Our Ref: Y/76/14/L

**Planning (Listed Buildings and Conservation Areas) Act 1990 (as amended)
Planning (Listed Buildings and Conservation Areas) Regulations 1990 (as amended)
Application for Listed Building Consent for Alterations, Extension or Demolition of a Listed
Building**

Development Application for listed building consent for 2 No proposed fences to secure the property

Location Berricourt Main Road Yapton

Proposed Plan @ 1:500

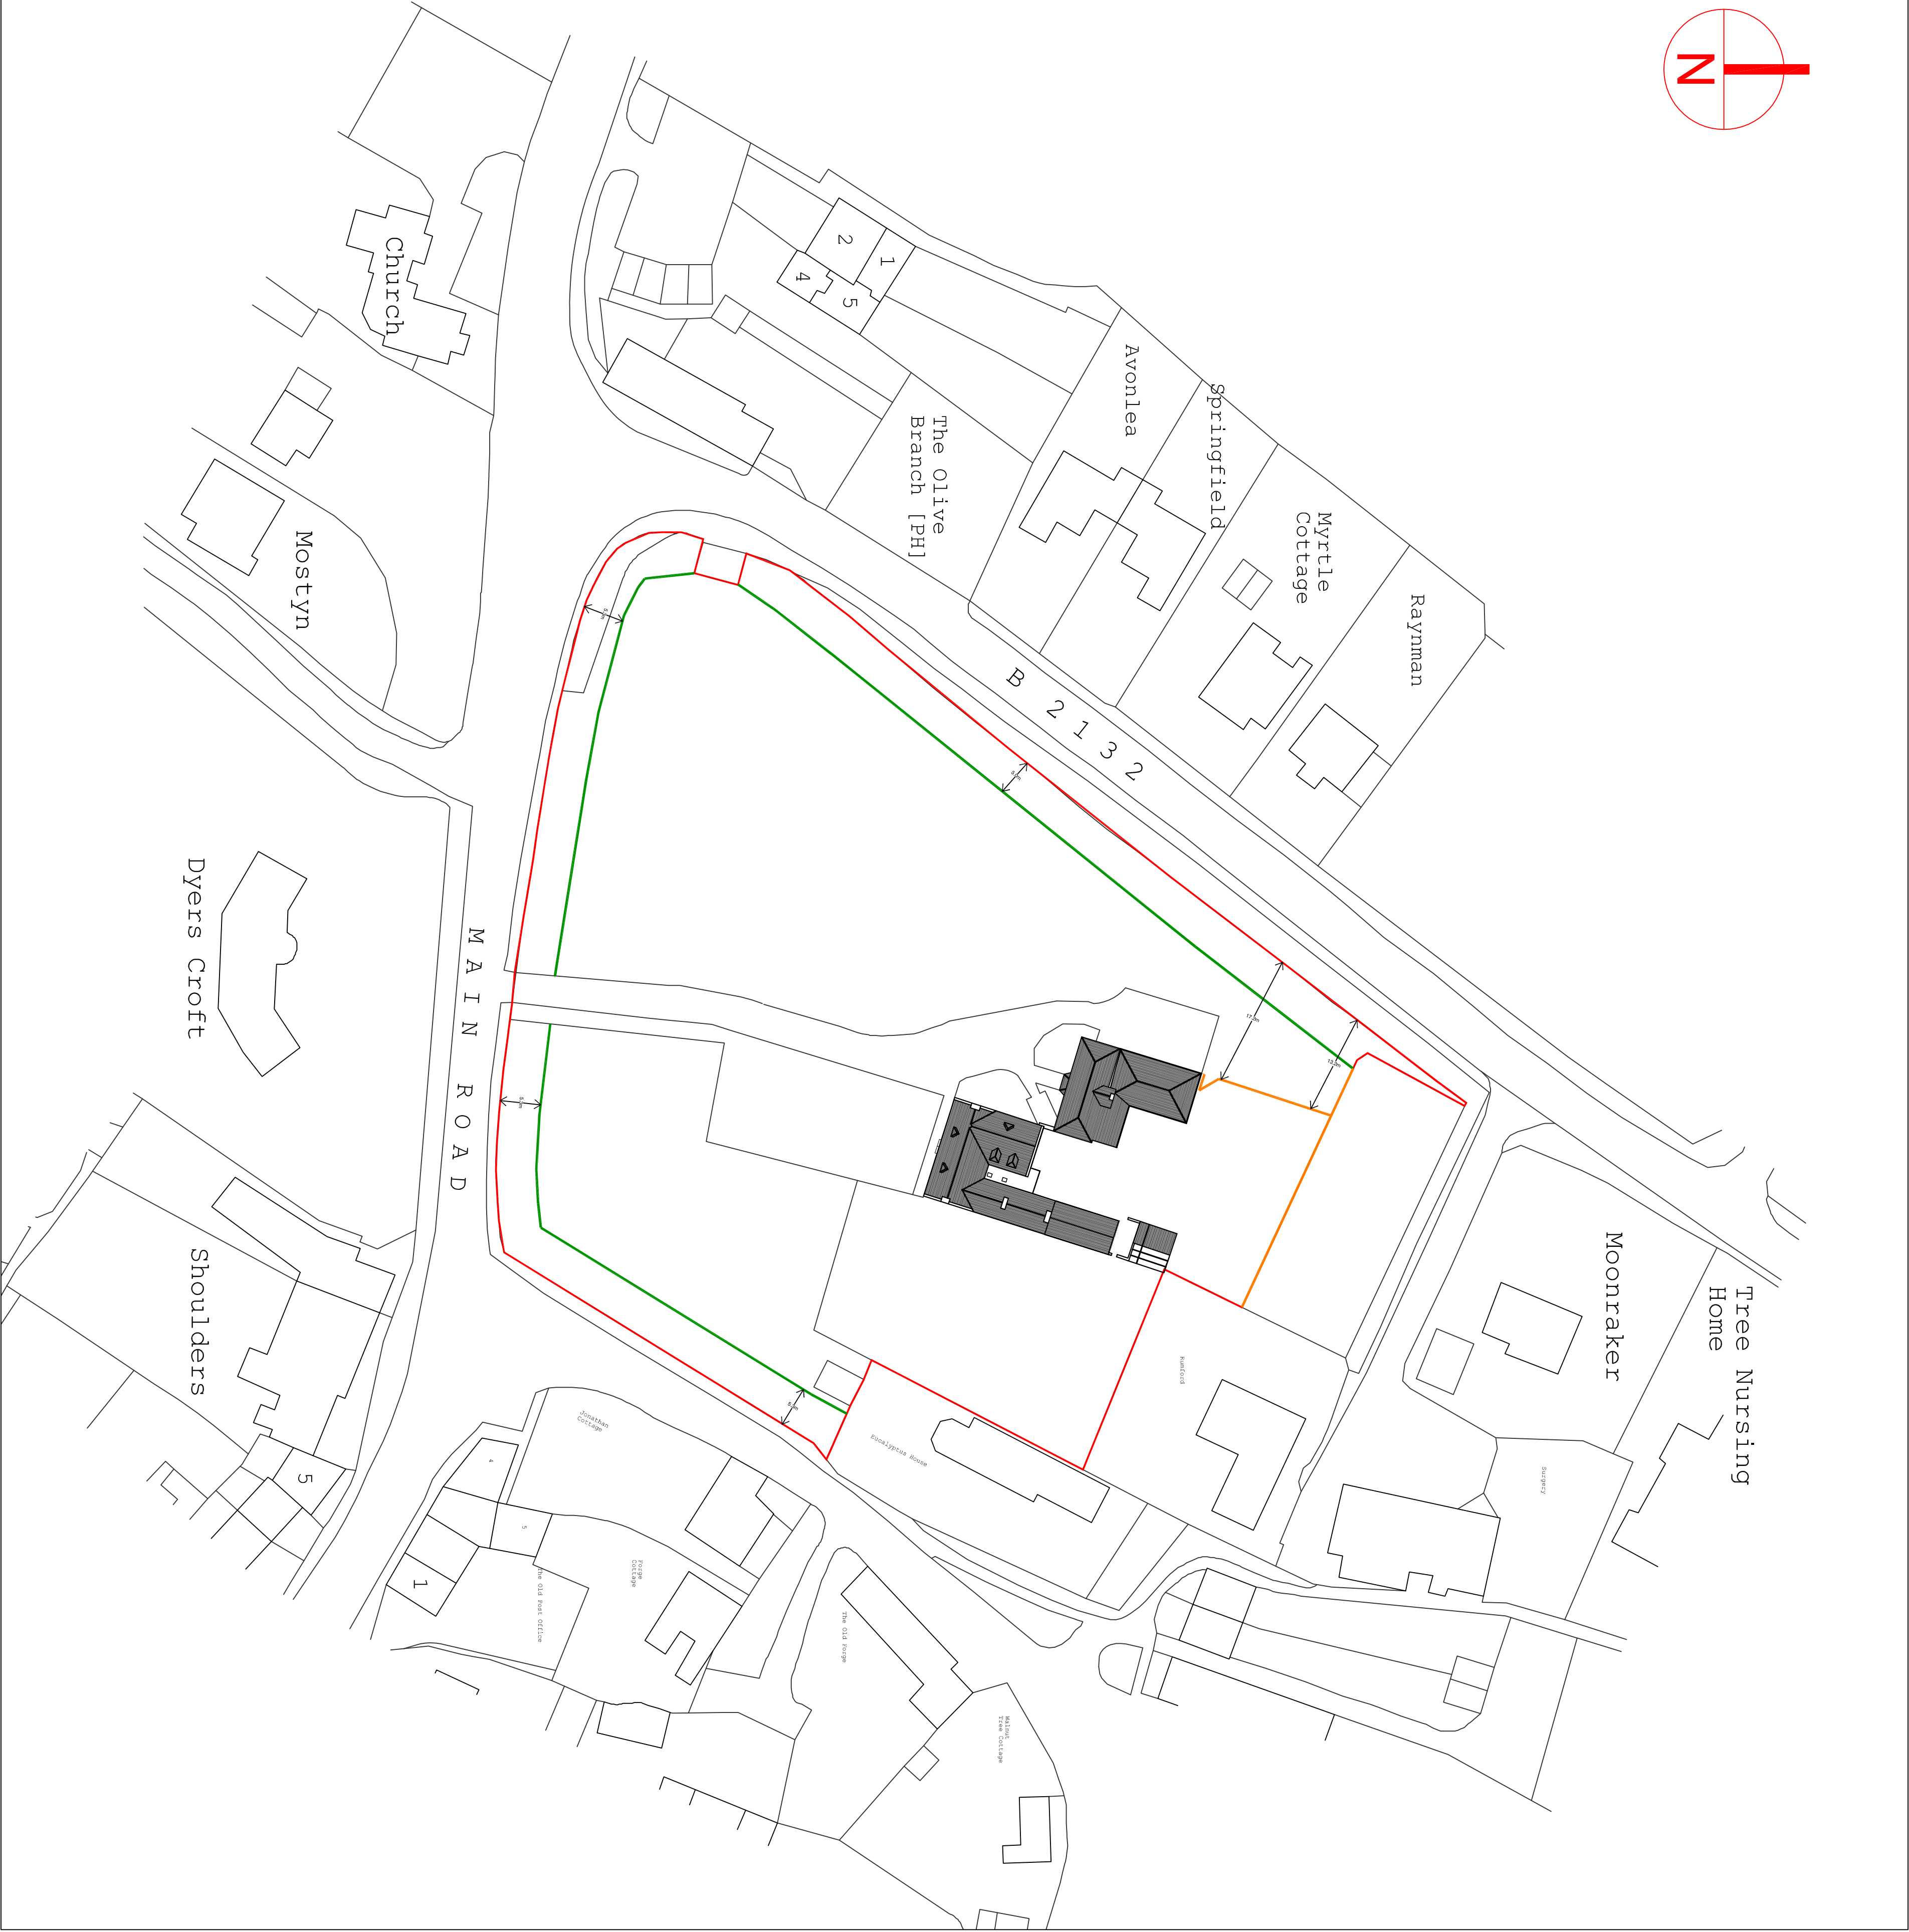
Please submit 1 electronic or 3 paper copies of a block/site plan at a scale of 1:500 or 1:200. Further details of what must be included on the plan can be found in the National Validation Requirements. Please provide measurements from the proposals to the site boundaries. Please include two measurements from each of the two different types of fences to the site boundaries in different places.

Please indicate the position of the board fence in a contrasting colour to the red edge for clarity.

Please provide a North point on the Location and Block plans.
